# Sedona Sun Acres Stormwater Drainage Study

Colorado Springs, El Paso County, Colorado

November, 2020

## Engineering Review

DRAINAGE MAP - EXISTING

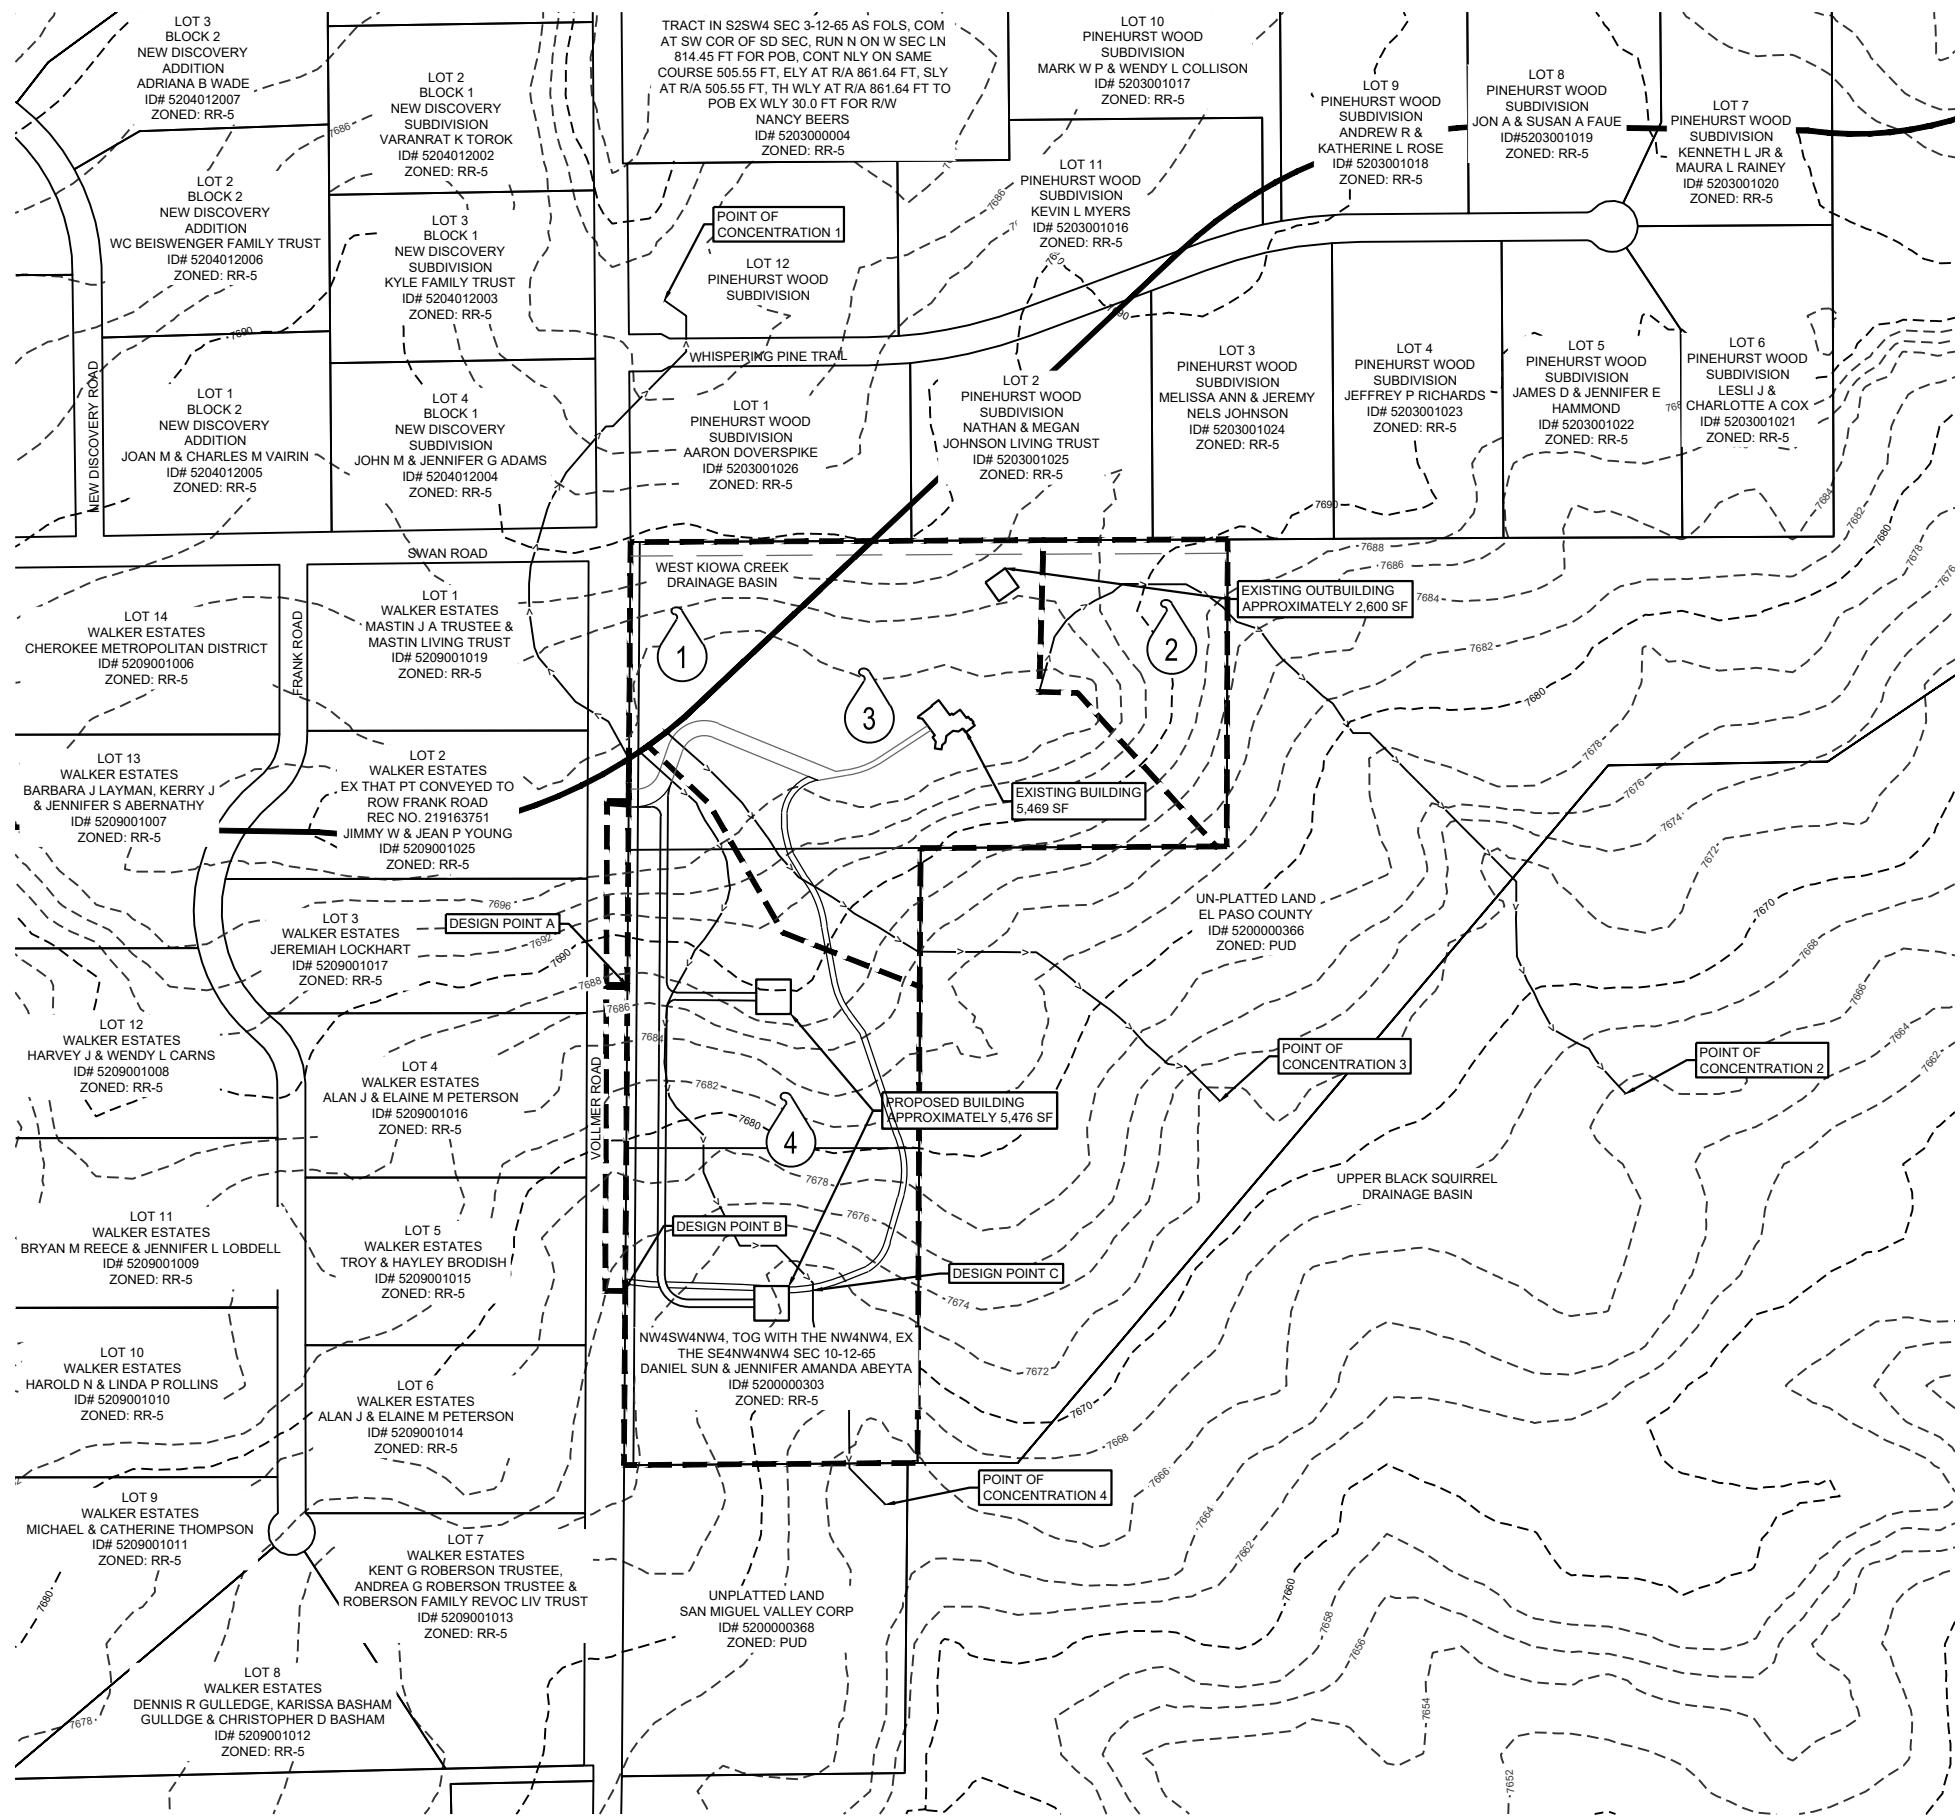
Provide a section for drainage basin fees. Increasing the impervious will require the payment of fees (Upper Black Squirrel). Show on the drainage plan/map the two basins.
